Approval of details reserved by condition imposed under ref Y/146/20/RES relating to Condition Nos 3 - in-curtilage storage spaces for houses & maisonettes, 4 - elevation & floor plan details of the proposed detached garages and 7 - external lighting.

Land at Street Buildings North End Road Yapton BN18 0DT

Arun District Council have decided to **REFUSE details reserved by condition for the following reasons:**

1.1 Generic, 10W (Lantern 10W)

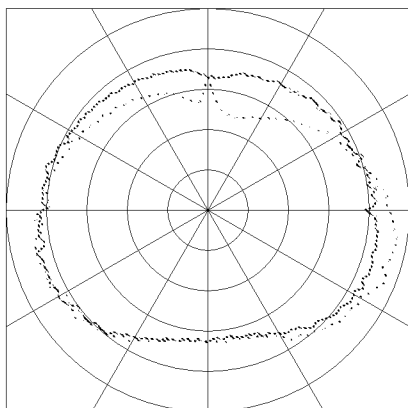
You have provided a Proposed Lighting Report which suggests the use of a generic 10W Lantern and

carbon 11W downlights (ref LBDL4S40). Although downlight suggests bat friendly, there is no information in the report to confirm this. Furthermore, the report does not make it clear where the lights are to be provided, their design or height.

Therefore it is not possible to discharge the condition on the basis of the information as provided and you will need to make a revised submission.
